East Anglia One North (EA1N) and East Anglia Two (EA2) Offshore Wind Farms

Planning Inspectorate Reference: EA1N – EN010077 & EA2 – EN010078

Deadline 5 - 3 February 2021

**East Suffolk Council's Response to Examining Authority's Action Points Following
Issue Specific Hearings 3, 4, 5 and 6**

| East Anglia TWO Offshore Wind Farm | | | Drg No | EA2-DEV-DRG-IBR-000693 | |

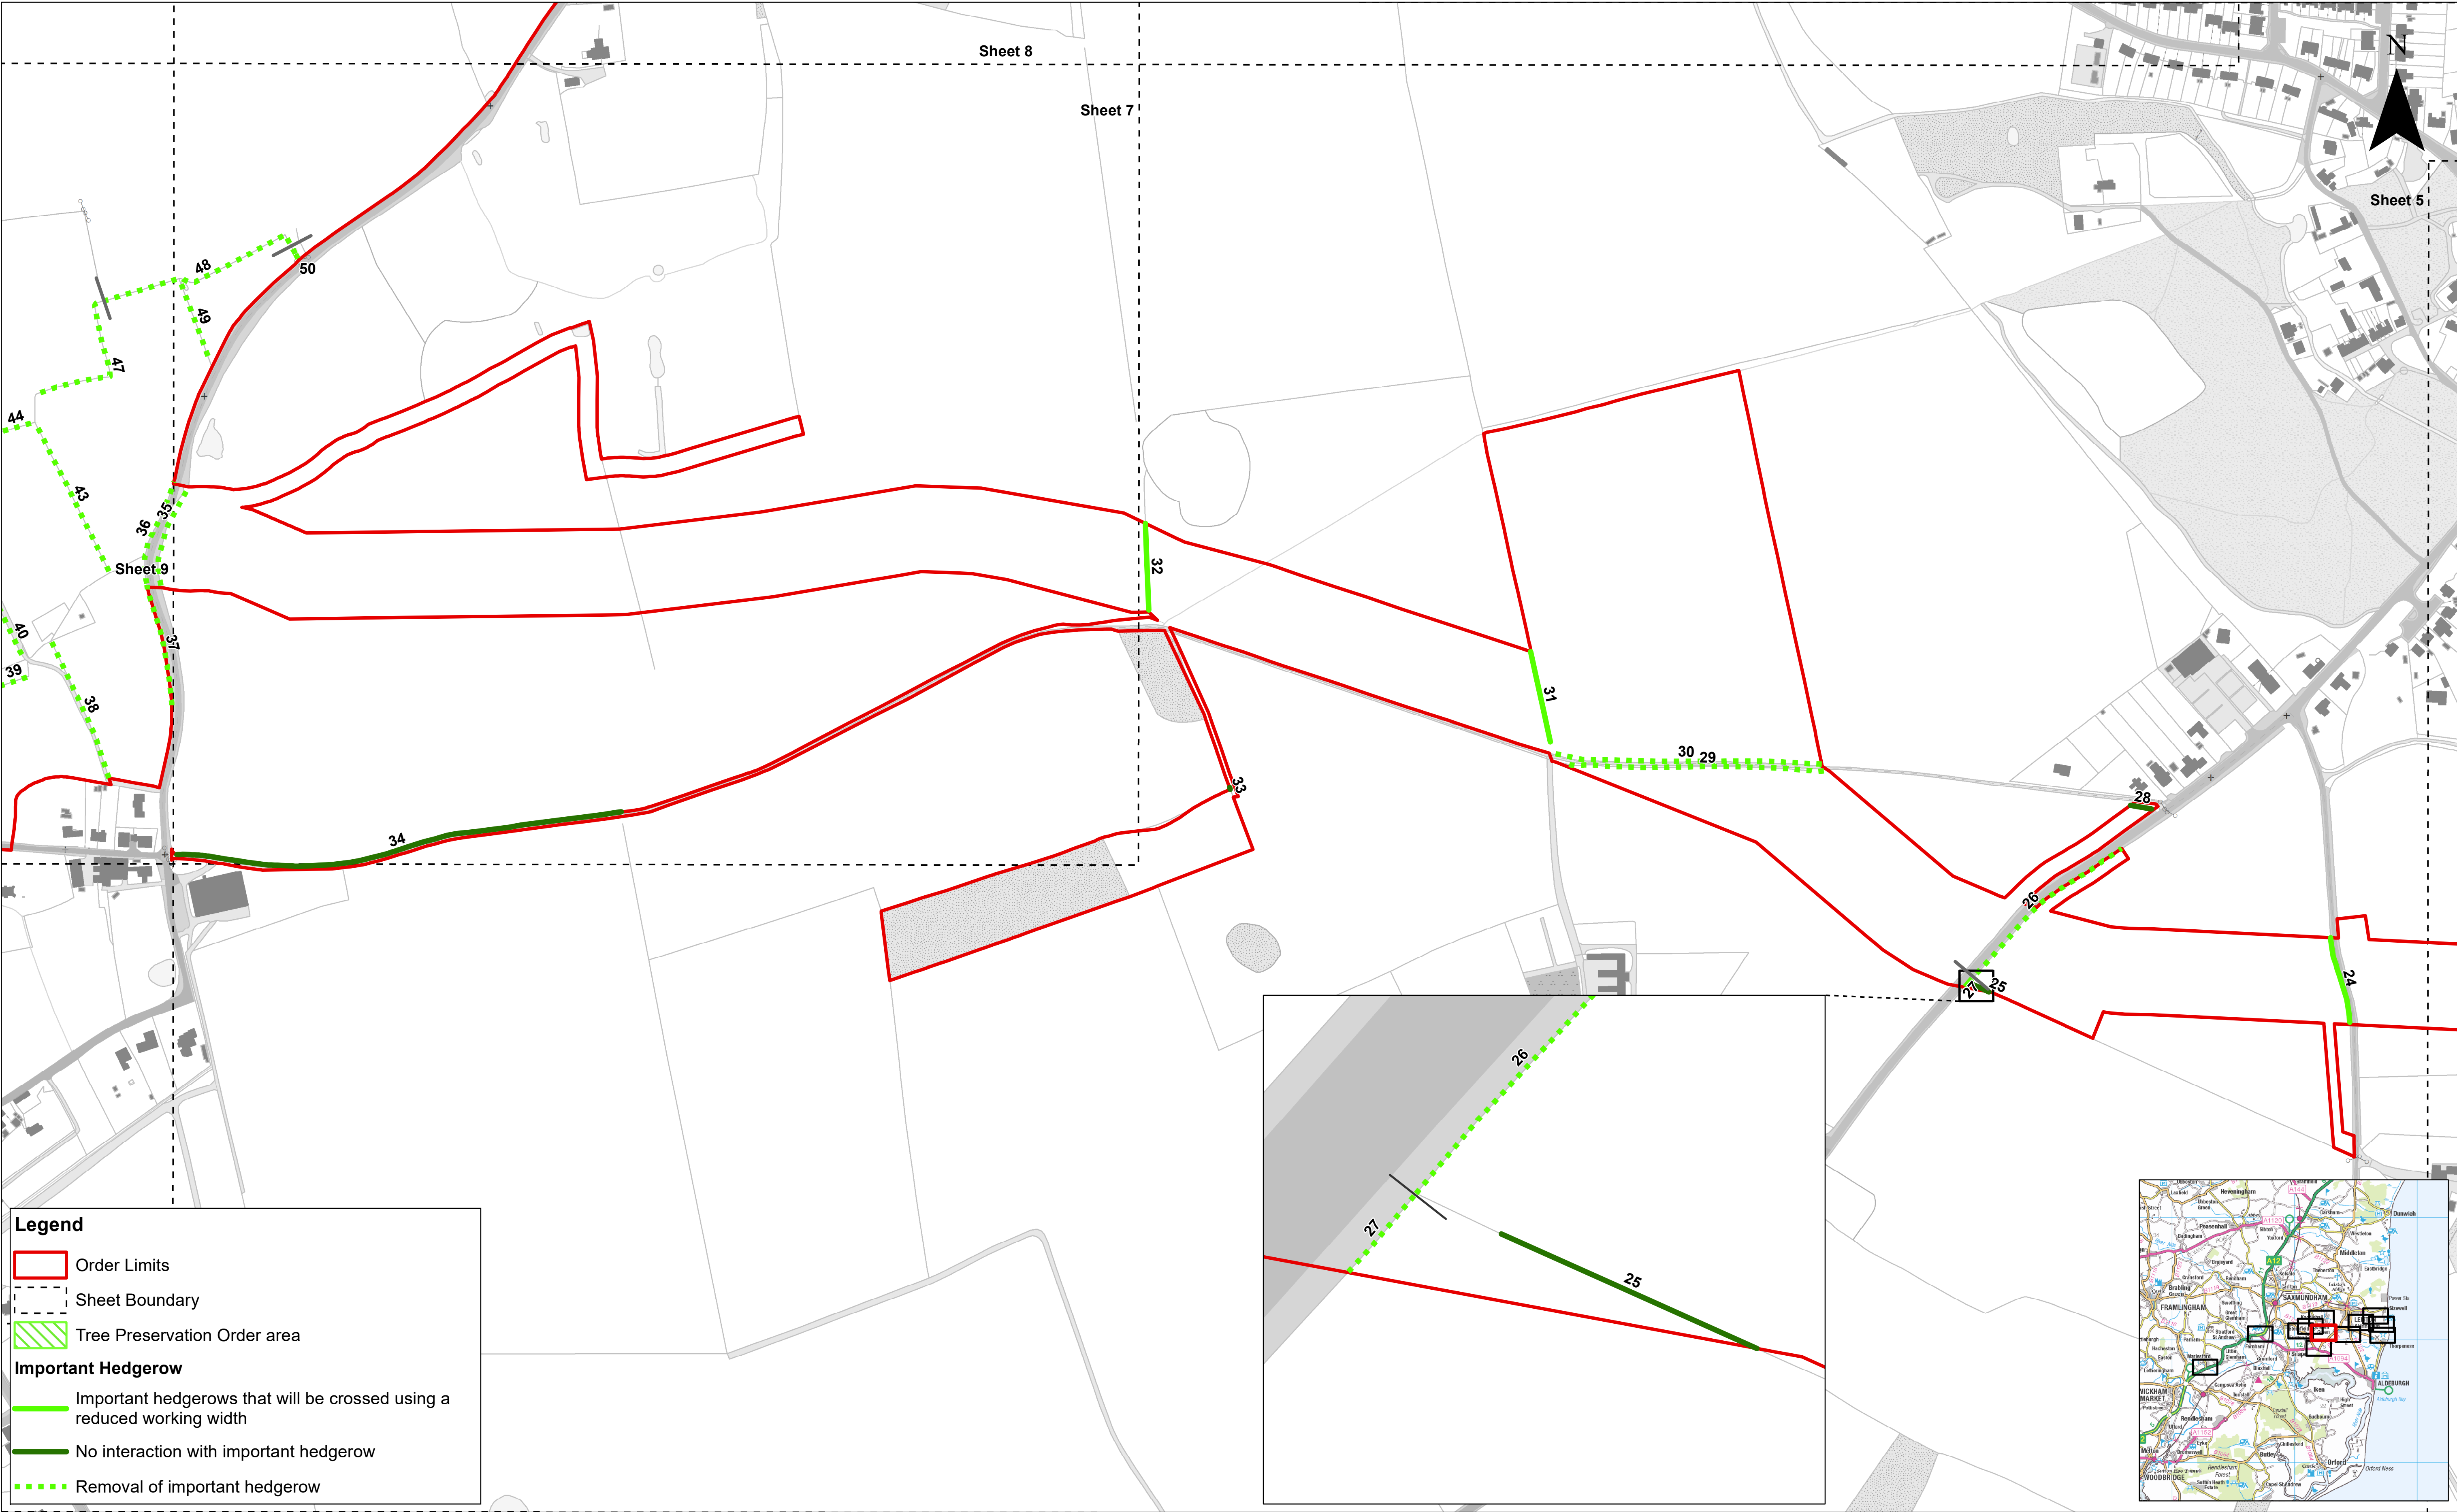
<p>ESC has been in discussion with the Applicants in relation to the removal of land parcel no.3 from the draft DCOs.</p> <p>Schedule 8 – Modification of compensation and compulsory purchase enactments for creation of new rights and imposition of new restrictions – ESC has no comments.</p> <p>Schedule 9 - Land of which temporary possession may be taken.</p> <p>ESC has been in discussion with the Applicants in relation to the removal of land parcel no.3 from the draft DCOs.</p> <p>Schedule 10 – Protective provisions – ESC has no comments.</p> <p>Schedule 11 - Hedgerows</p> <p>ESC seeks clarity regarding the hedgerows identified within Schedule 11 of the draft DCOs.</p> <p>Hedgerows marked 1 and 2 are identified within Schedule 11 (REP3-011) as being removed but on the Important Hedgerows and Tree Preservation Order Plan (REP3-010) they are identified as being crossed with a reduced width. Annex 1 of the OLEMS document (REP3-030) identifies hedgerows 1 and 2 as being subject to full or partial removal. Clarification on this is required.</p>

<p>Clarification is also required in relation to hedgerow marked 28 which is identified on the Important Hedgerows and Tree Preservation Order Plan (REP3-010) as being removed but is not identified within Schedule 11 as being removed and identified in Annex 1 of the OLEMS (REP3-030) as not subject to interaction.</p> <p>The interaction identified within Annex 1 of the OLEMS (REP3-030) in relation to a number of hedgerows does not appear to correspond to the interaction identified within Schedule 11 of the draft DCOs (REP3-011) and the interaction identified on the Important Hedgerows and Tree Preservation Order Plan (REP3-010). Further clarification as to the reasons for this is required. Does Annex 1 identify a greater number of important hedgerows to be crossed with a reduced width as some of these will be crossed with a width less than 32m but greater than the draft DCOs definition of reduced width which is 16.1m?</p> <p>Schedule 12 – Trees subject to tree preservation orders – ESC has no comments.</p> <p>Schedule 13 – Deems licence under the 2009 Act – generation assets – ESC has no comments.</p> <p>Schedule 14 – Deemed licence under the 2009 Act – offshore transmissions assets – ESC has no comments.</p>
